Consultation Response from: KC Environmental Health (Pollution & Noise Control)		
2021/93644 Low Farm, Wakefield Road, Flockton, Huddersfield, WF4 4BB		
Erection and operation of grid-connected solar photovoltaic farm to supply up to 49.9MW, with ancillary infrastructure and landscaping and biodiversity enhancements		
Responding Date: 29 June 2022	Responding Officers: Shirley Reynolds Mohammed Nasim	Responding Ref: WK202219913
<u>Comments</u> <u>Construction Environmental Management Plan</u> In our earlier consultation dated 25th January 2022, we commented on the potential for loss of amenity to the occupiers of neighbouring properties from noise/vibration, dust or other emissions during the construction. In support of the application a Construction Traffic Management Plan (CTMP), by Hydrock, dated 8th June 2022, ref: 17298-HYD-XX-XX-RP-TP-7001-P06, has been submitted. This in part details the actions to be taken to mitigate the loss of amenity to local residents from the construction phase of the proposed site. <u>Hours of operation</u> The CTMP is identified as a live document which will be reviewed, monitored and updated as necessary, with construction anticipated to be ongoing

Figure 2.1: Indicative Construction Compound

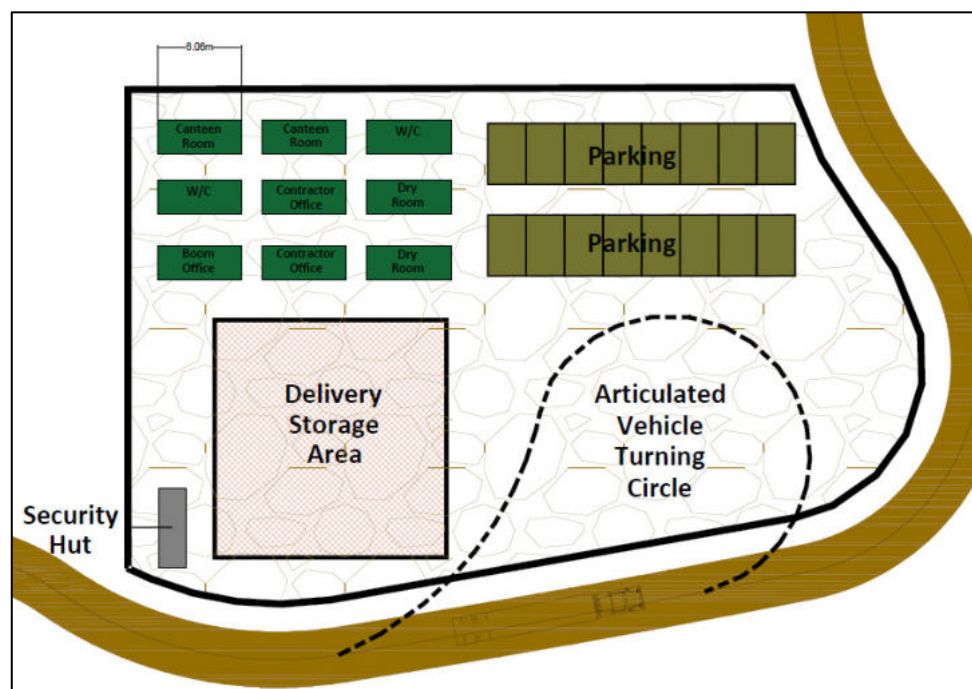
very little site specific information has been provided. The CTMP has not identified where water for damping down will be taken from. As this is a major control mechanism, we would expect confirmation of sufficient quantities of water to enable cleaning and damping down. The access tracks will be made up of compacted material and may not be suitable for conventional road sweeping. The CTMP must identify the most appropriate method for dust control on the site and clarification of this point is required.

As the cleaning of vehicles leaving site is a mitigating factor, we would normally expect to see a site plan indicating the position of exits and wheel wash facilities. This has not been provided.

Overall we require more site specific details in regard to dust suppression, we expect the dust suppression measures on a site of this size to take into consideration the Institute of Air Quality Management (IAQM) Guidance on the Assessment of Dust from Demolition and Construction v1.1 Feb 2014, in particular, the measures detailed in the “Mitigation for all sites” tables in Section 8 of the document.
